**KIRKLEES METROPOLITAN COUNCIL
INVESTMENT & REGENERATION SERVICE**

Reference No: 2019/62/90501/E

Site Address: 5, Cross Park Street, Earlsheaton, Dewsbury, WF12
8AG

Description: Erection of double garage

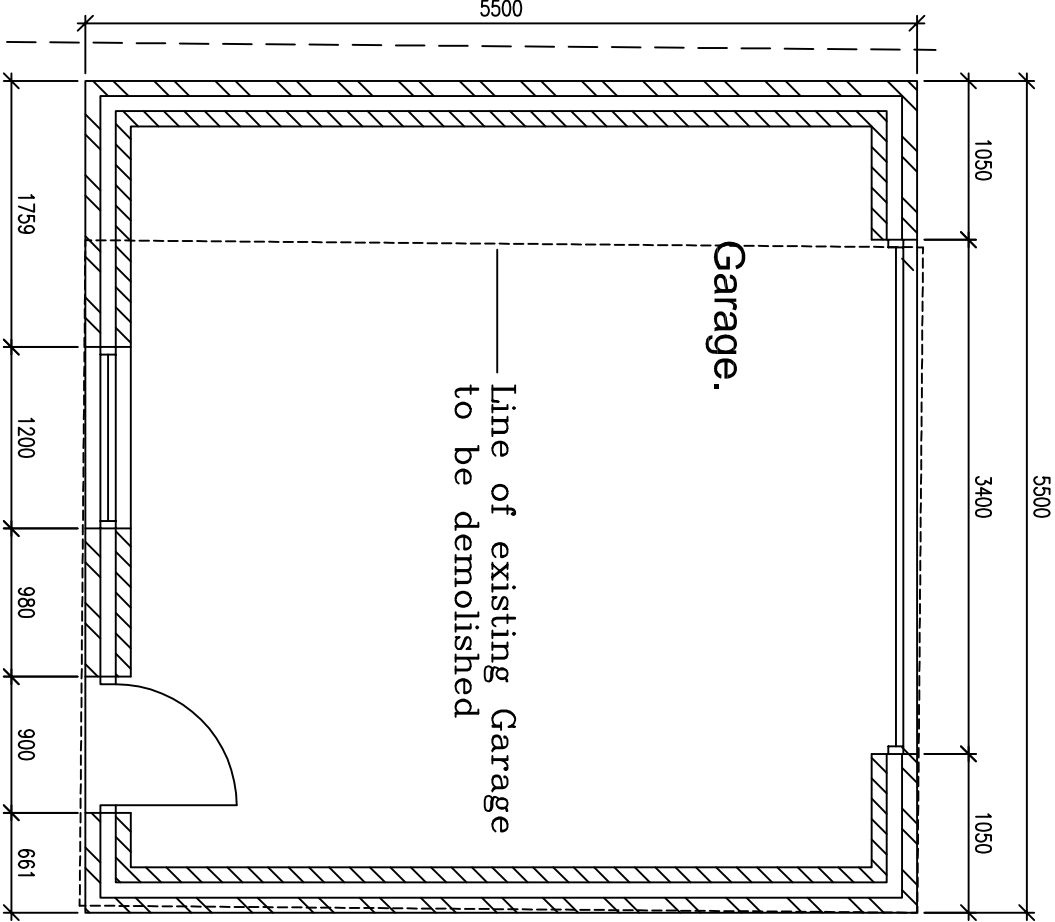
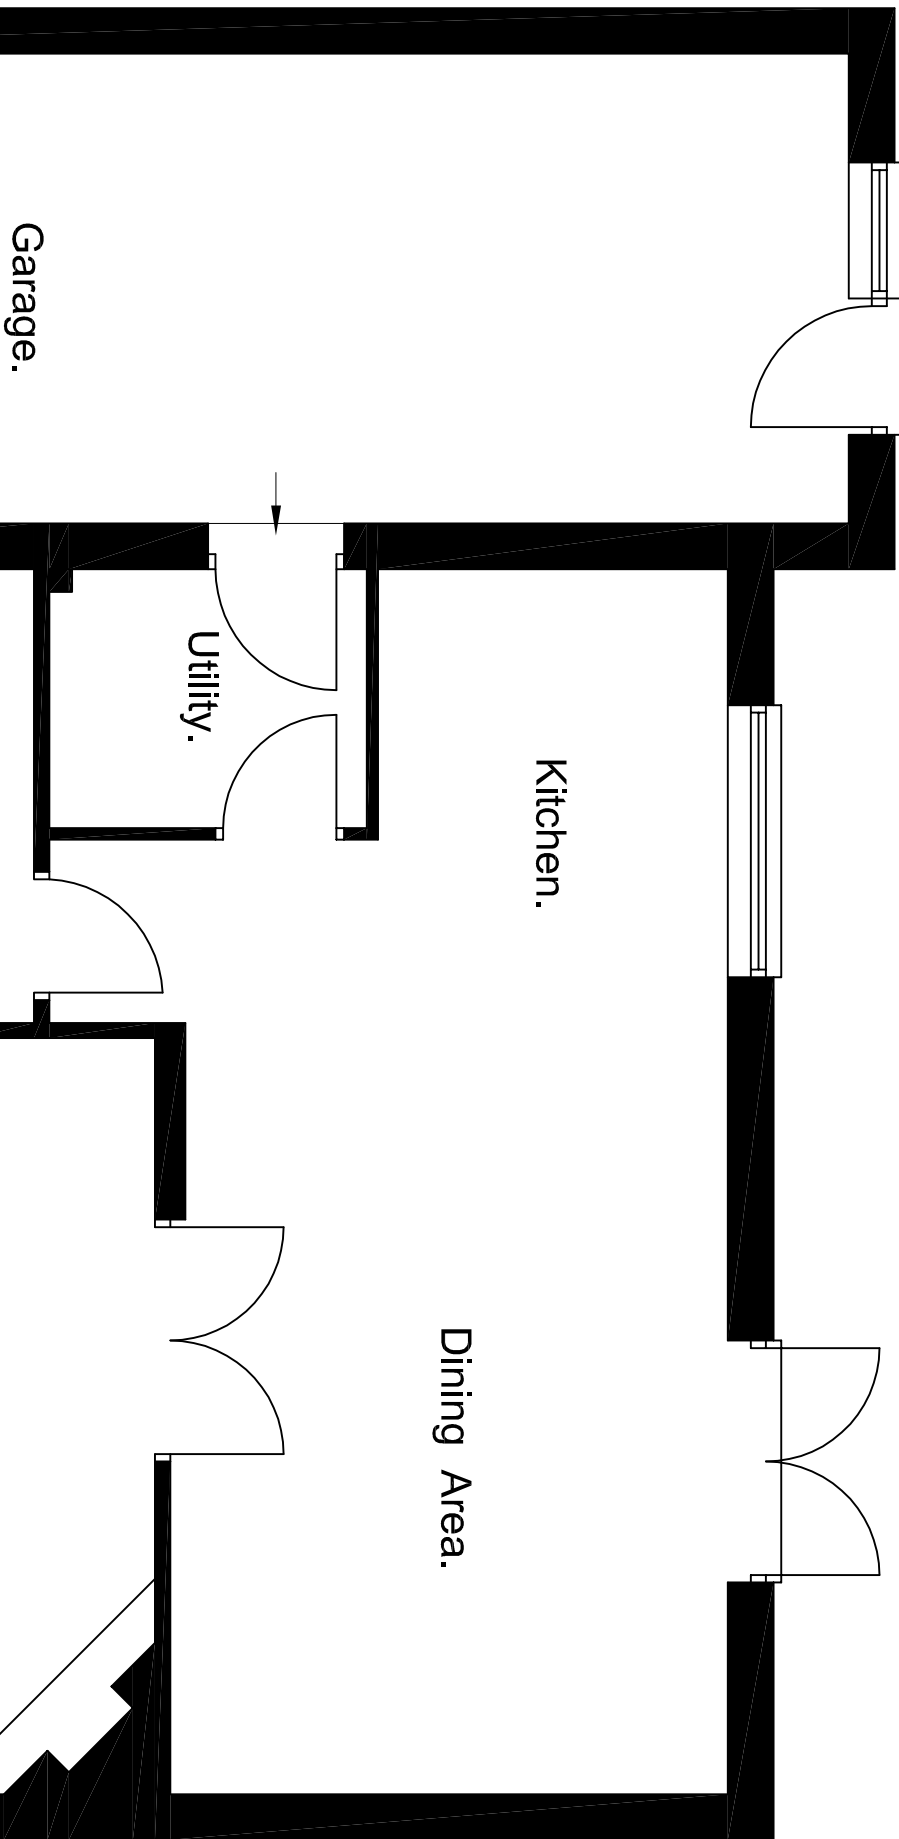
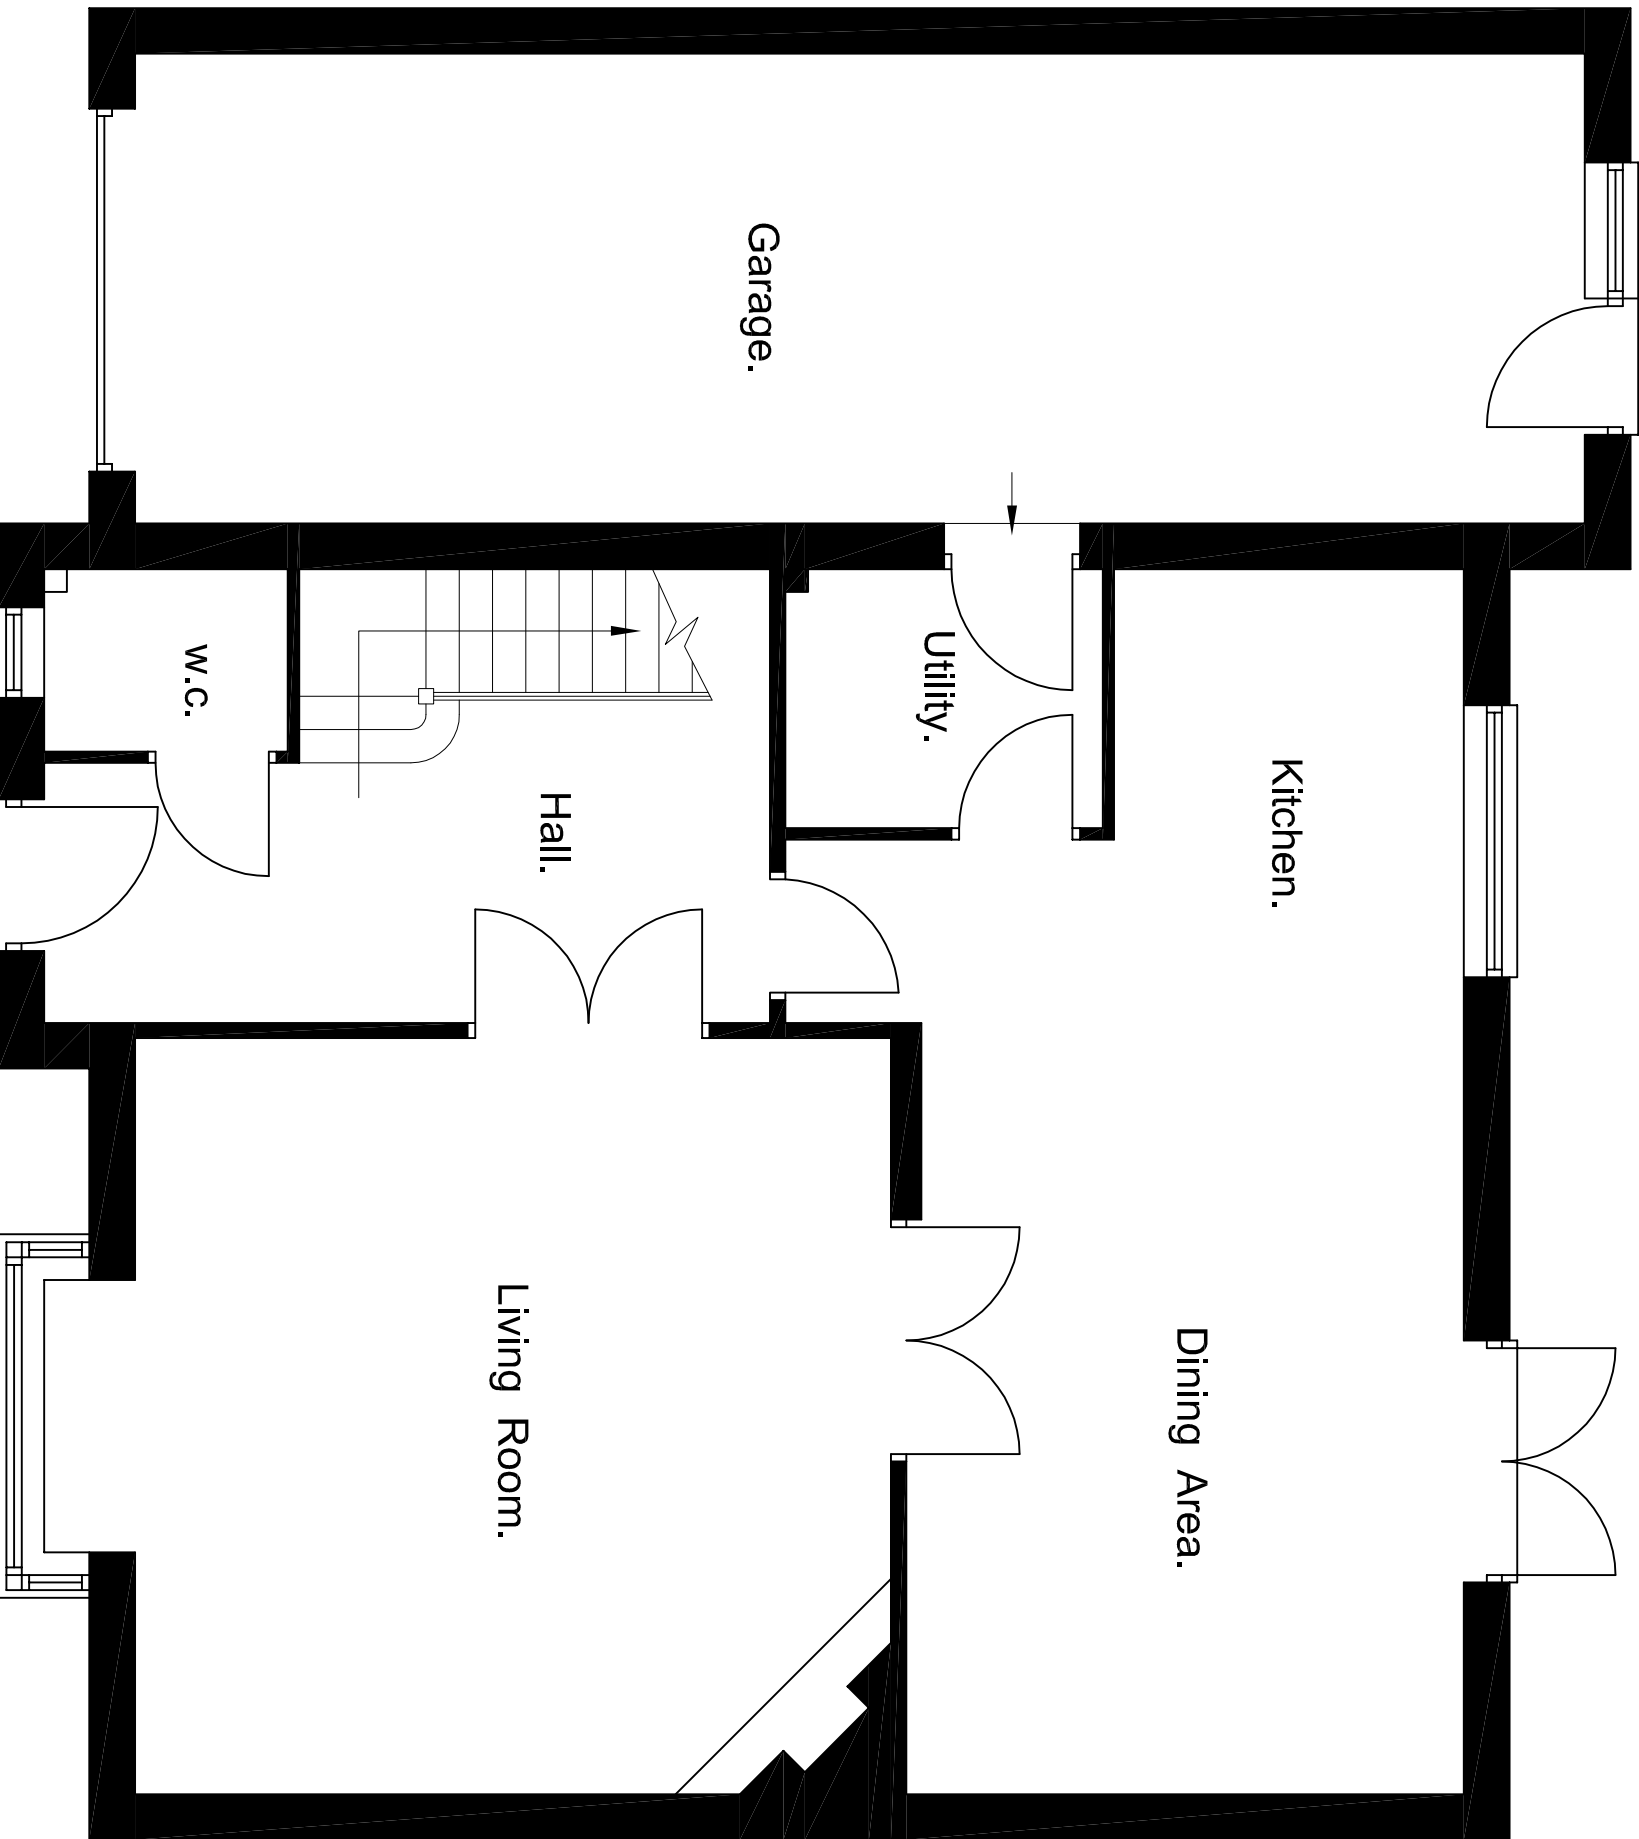
The officer entered into discussions with the agent regarding the submitted certificate as the red line boundary was shown up to the adopted highway. Certificate B was received on the 26.02.19. Alongside this, the officer entered into several discussions with the agent regarding the height of the proposed garage. Amended plans to reduce the scale to an appropriate height were received on the 21.05.19.

As outlined on the submitted plans, the footprint of the proposed outbuilding will be increased as part of this application. However, it would not result in the overdevelopment of the site. Nevertheless, amendments have been secured to significantly reduce the height of the proposed garage.

Amendments have been sought to reduce the height and pitch of the proposed garage. This will help alleviate some of the harm on visual amenity and the character of the area.

Comment: Amendments have been sought to reduce the height of the proposed garage. As such, the impacts on residential amenity on balance have been considered acceptable.
